Address: The Carr 3 Carr Lane Huddersfield HD8 8BR

Application number: 2022/62/90484/E	
What is the application for?:	Erection of detached garage
Address of the site or building:	Shepley Carr House, Carr Lane, Shepley, Huddersfield, HD8 8BR
Postcode:	HD8 8BR

Drawing
Planning Scheme - Proposed Site Sections and Garage GA

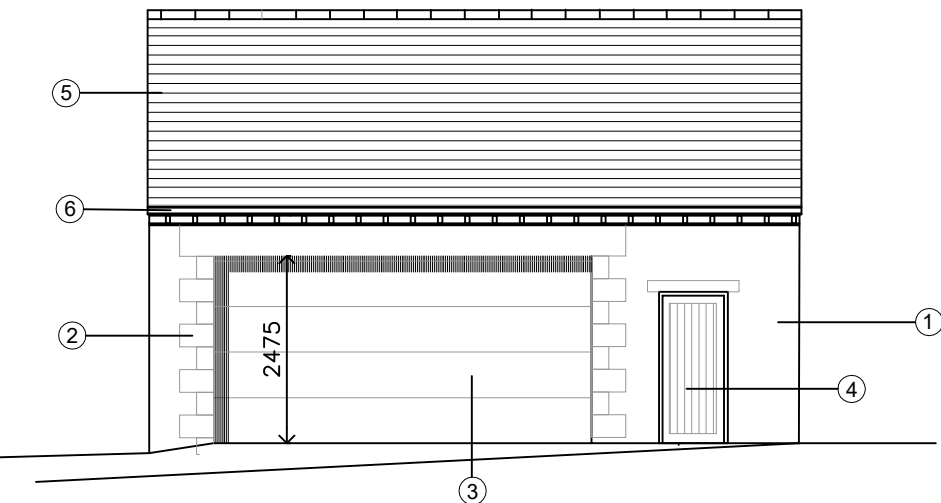
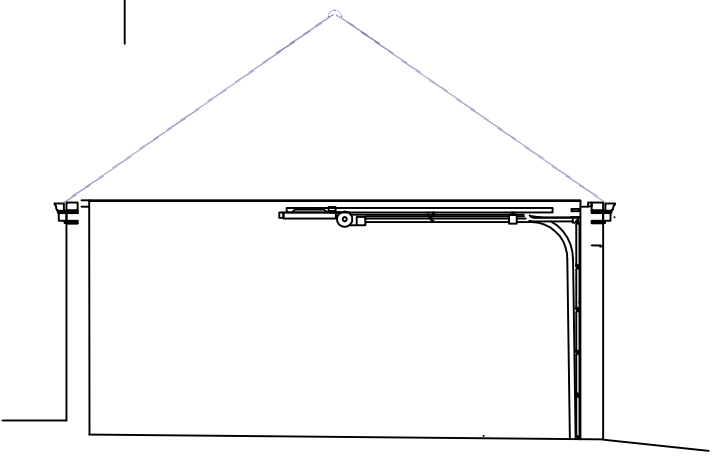
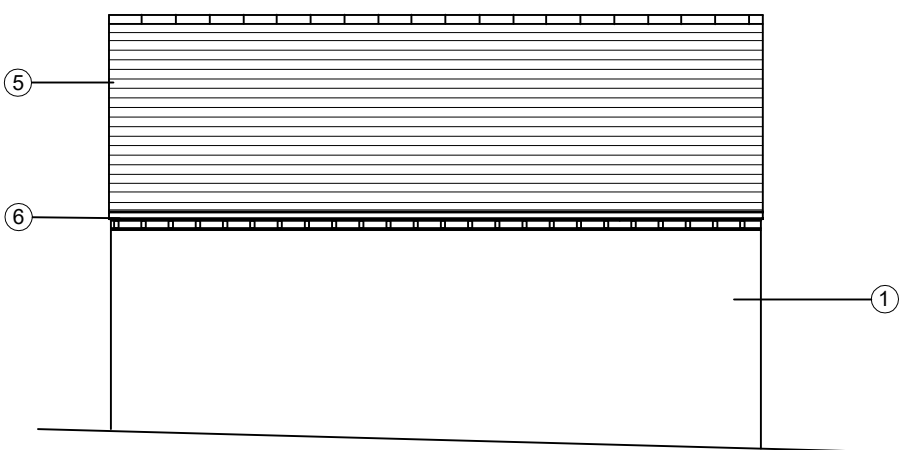
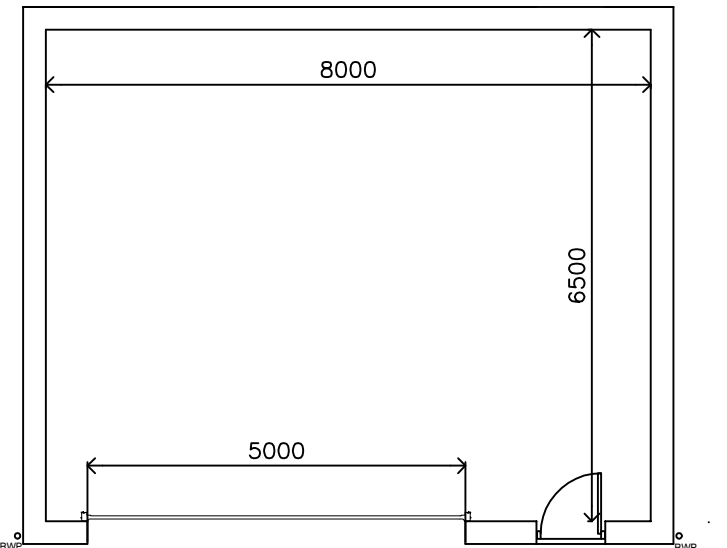
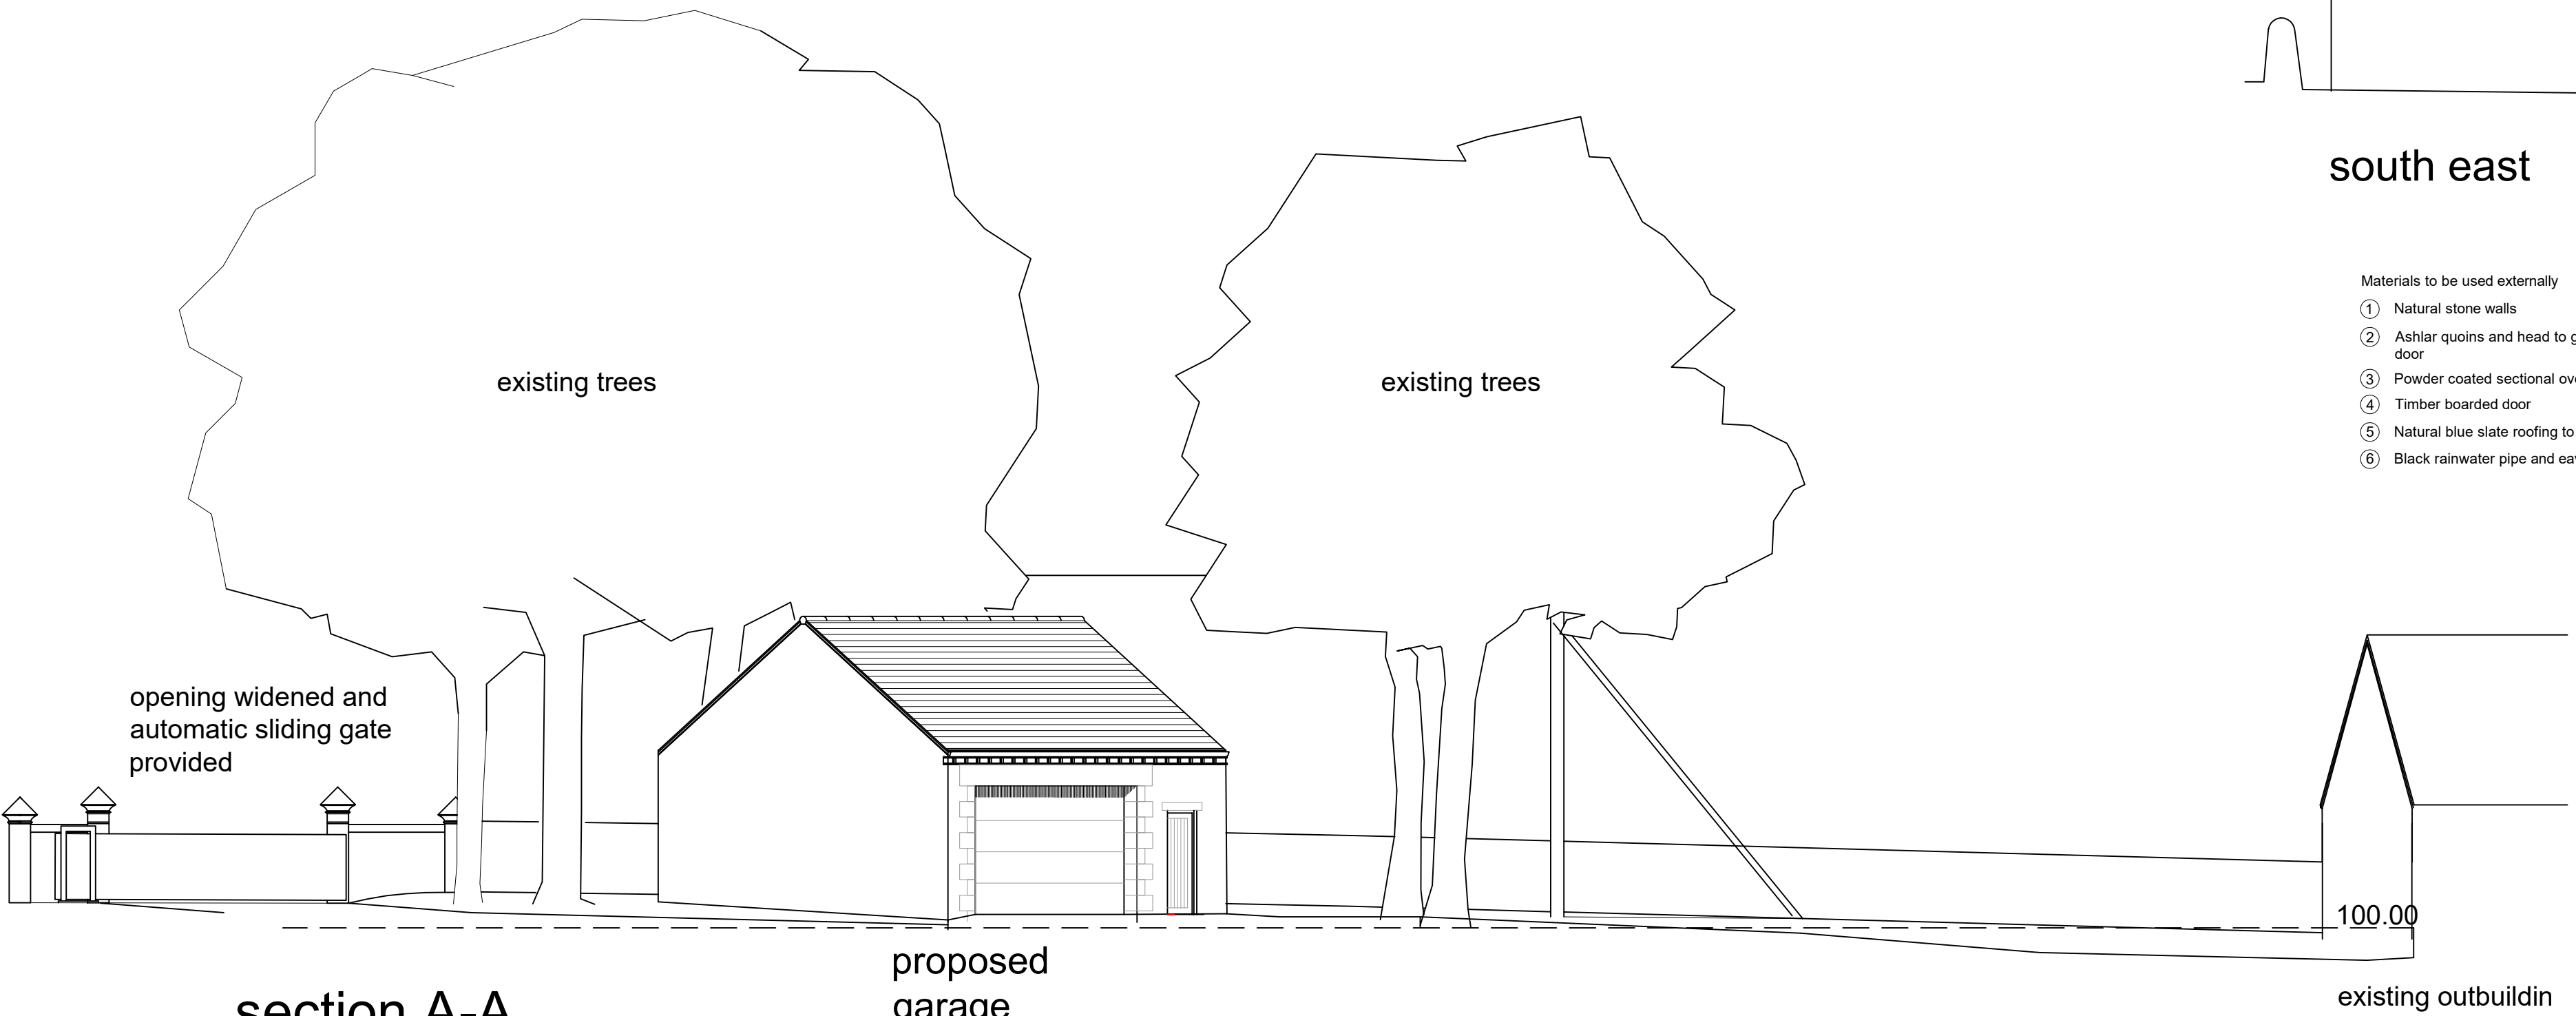
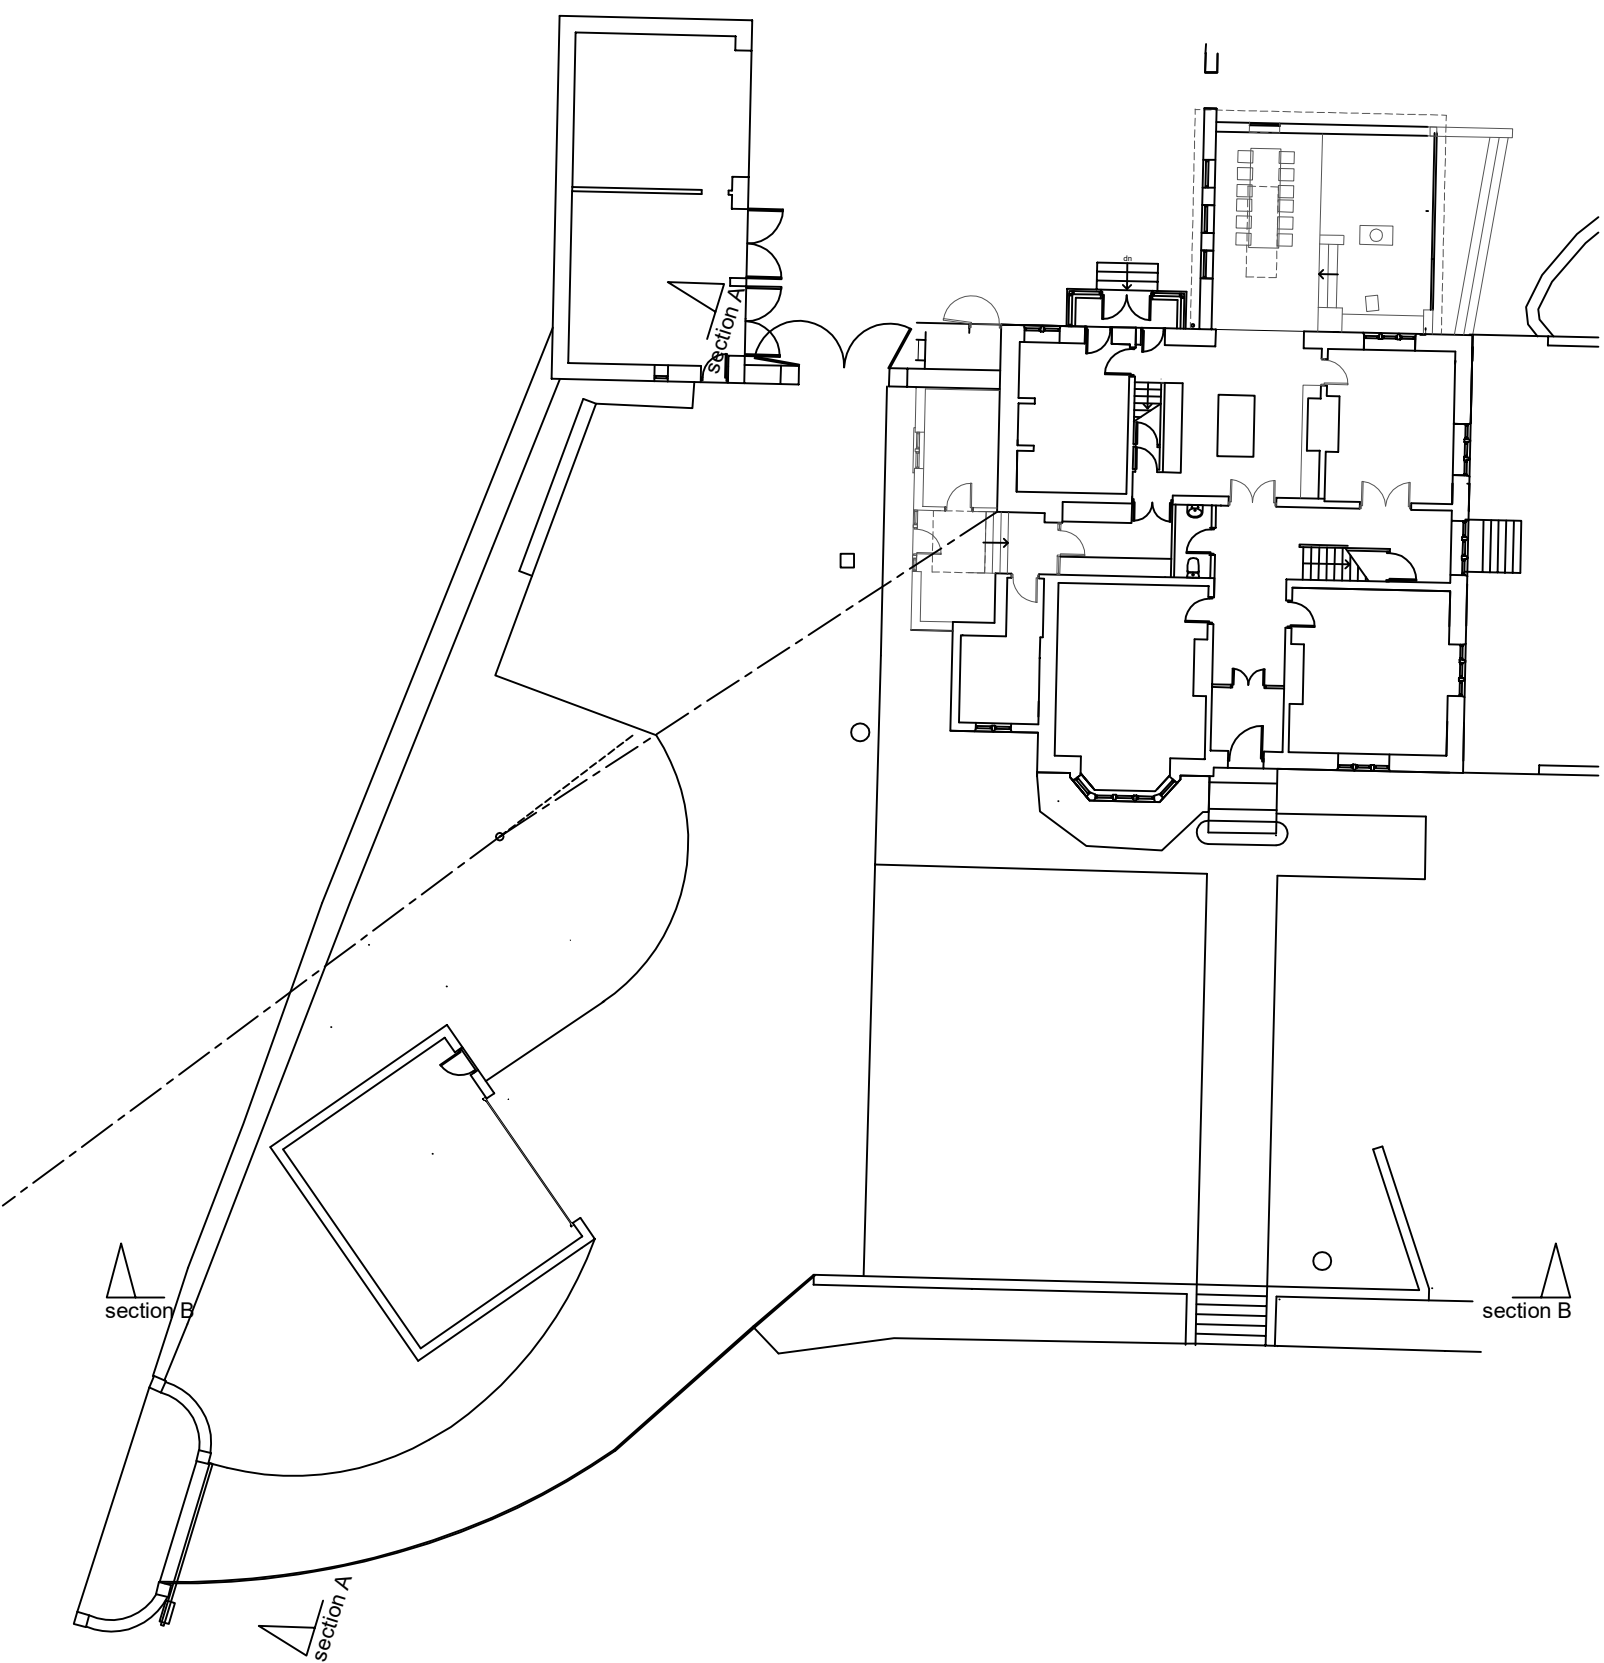
The proposed garage continues to show the same lack of architectural detail with formed part of the reasons for refusing the previous application for a detached garage at the same address.

Not only does the proposed garage display a lack of architectural detail, it would in fact be built directly in front of the facade of the original architect-designed Coach House and would obscure significant architectural details of the original Coach House which forms an important part of the Non-Designated Heritage Asset, specifically by covering up the majority of the lancet windows to the upper storey, the Reformed Gothic window below and the chamfered stone door case.

The roof design of the proposed structure is not in keeping with the host dwelling and does not reflect the architectural features of this historically significant building, and surrounding character of historic buildings and is therefore inappropriate for an ancillary building within this setting.

The application specifies that the garage would have a blue slate roof, I can understand the applicant specifying a blue slate roof to match the main building and in order to reduce the costs but all the surrounding cottages and outbuildings, including the original Coach House have traditional Yorkshire stone slate roofs. The use of blue slate would make the new building appear less subservient than it might otherwise appear, if it were to have a York stone roof. The design also lacks the skew stones which are an important architectural feature of Shepley Carr House, being present on both the main house and the Coach House, illustrating that the application does not take into consideration the setting or vernacular features of its surroundings

Furthermore, the specified sectional garage door would be incongruous within the historic setting, particularly on the front facade of a heritage asset.

Shepley Carr House : Proposed Layout

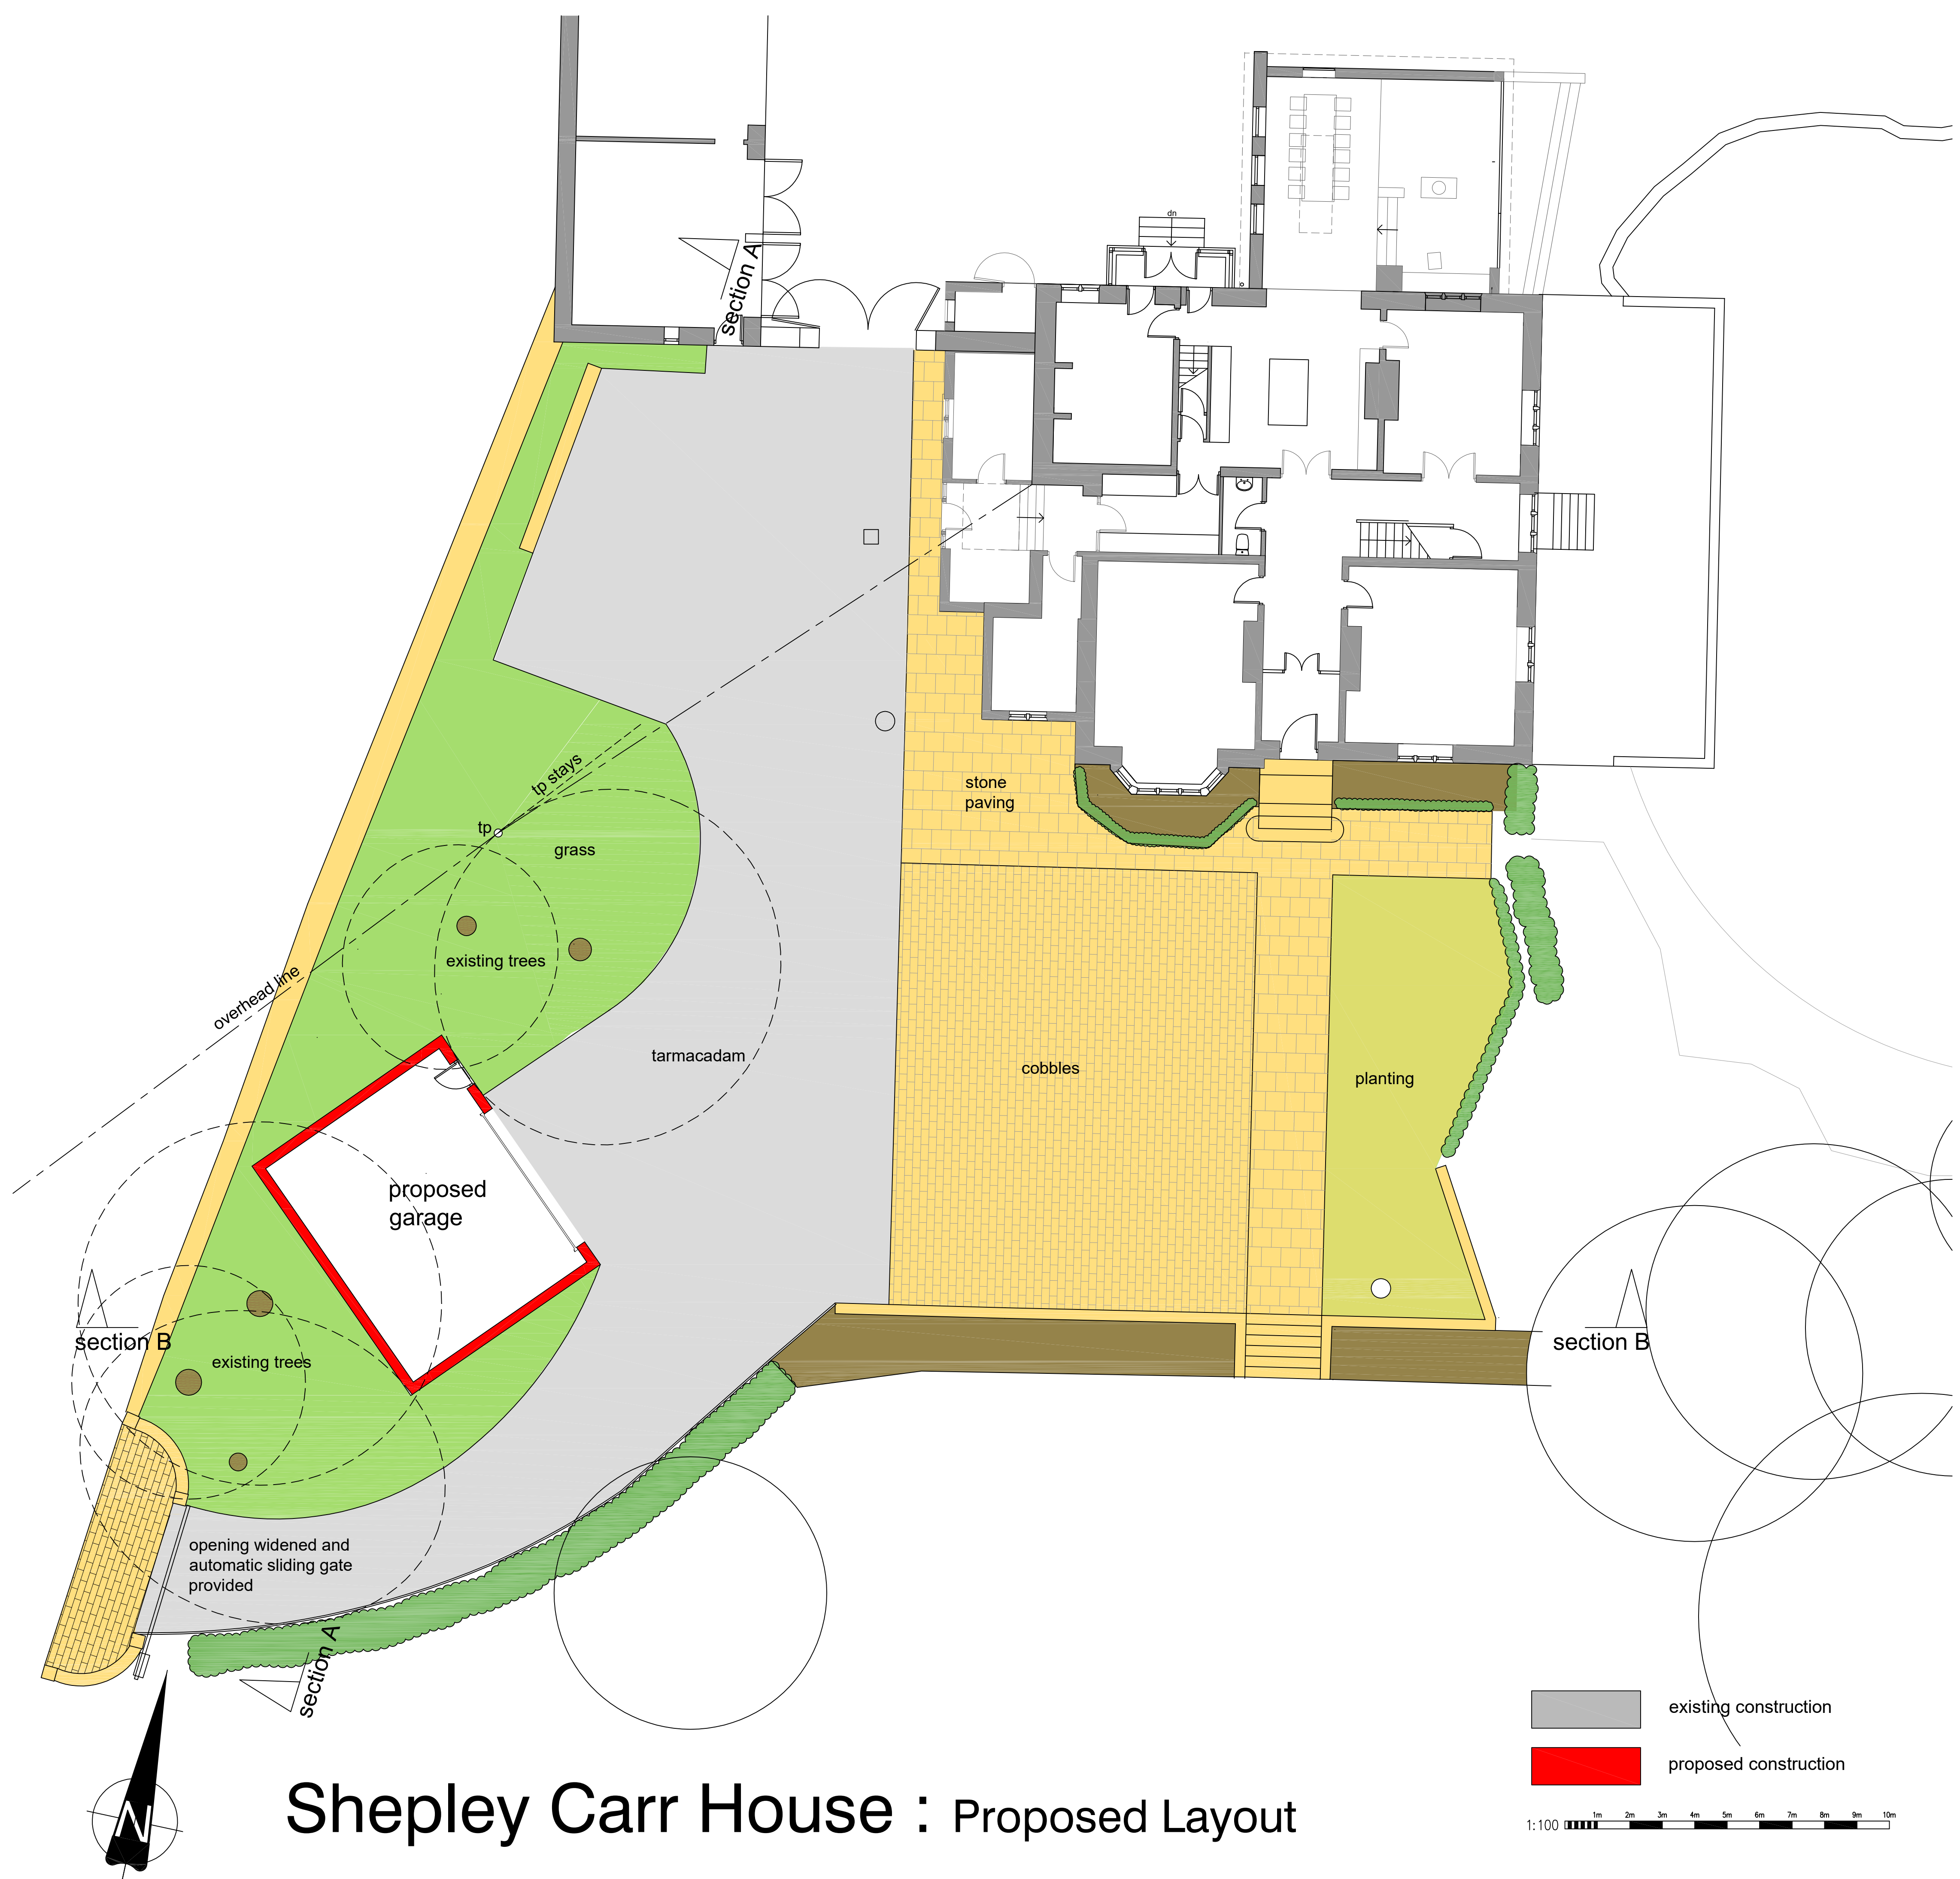
The dry stone wall forming the boundary of the site and which forms part of the Heritage Asset is currently on a fragile state and would inevitably fall down due to the undermining caused by both the proposed garage block and the erection of the proposed telegraph pole.

The Planning Statement states that the structure is not proposed to be built within 2 metres of the boundary however the accompanying plans show the re-siting of the existing telegraph pole to be directly on the boundary with my property and approximately 3.5 metres closer to my dwelling than its current position and immediately to the front of my house. Currently the telegraph pole is unobtrusively sited against a backdrop of mature trees, this proposal would have a negative impact in terms of Visual amenity not only for the appli
